Your Ref: OWPC19910
Our Ref: FP/171/18/PL 29-06-2018
Please ask for:
Mr S Davis

Erection of 18 No. dwellings, creation of new access, landscaping & associated works.
Land at Stanhorn Grove Felpham

Thank you for your internet representation made on 4th September 2018 which has been recorded as '**an objection**' with the comments as follows:

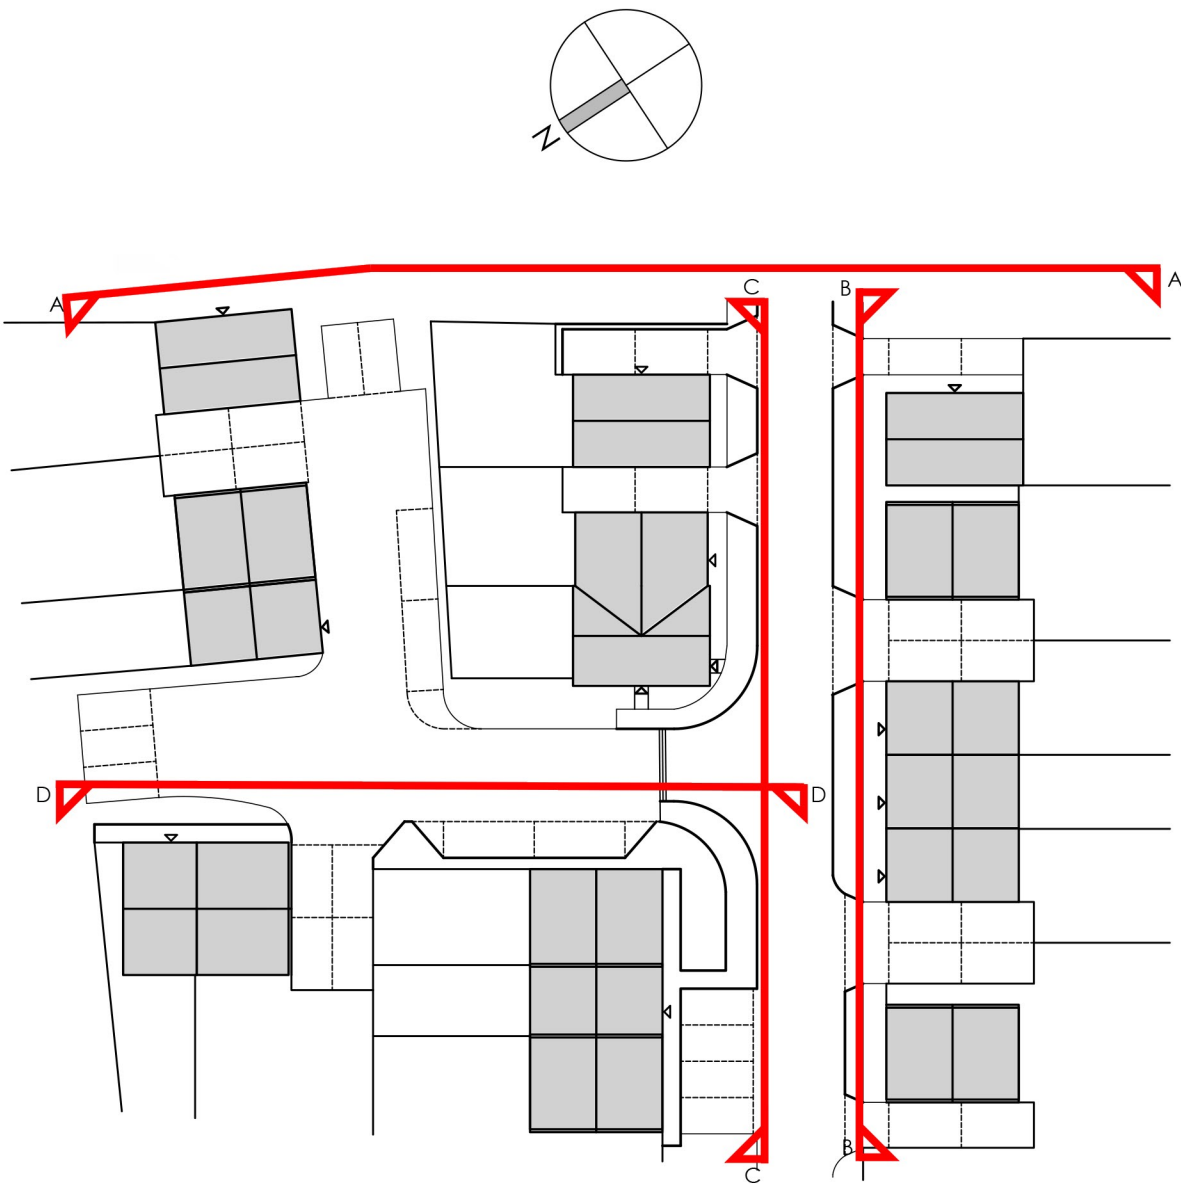
The ground clearly falls away from Stanhorn Grove in a westerly direction through the proposed development and this does not appear to be clearly conveyed in the plans or sections therefore the potential impact of levels in terms of flood risk, visual impact and relationships to existing structures is difficult to read. I refer to Drawing 17094-PL-5-01, 'Street Scenes', which shows neither Stanhorn Grove Road nor the adjacent DWH properties.
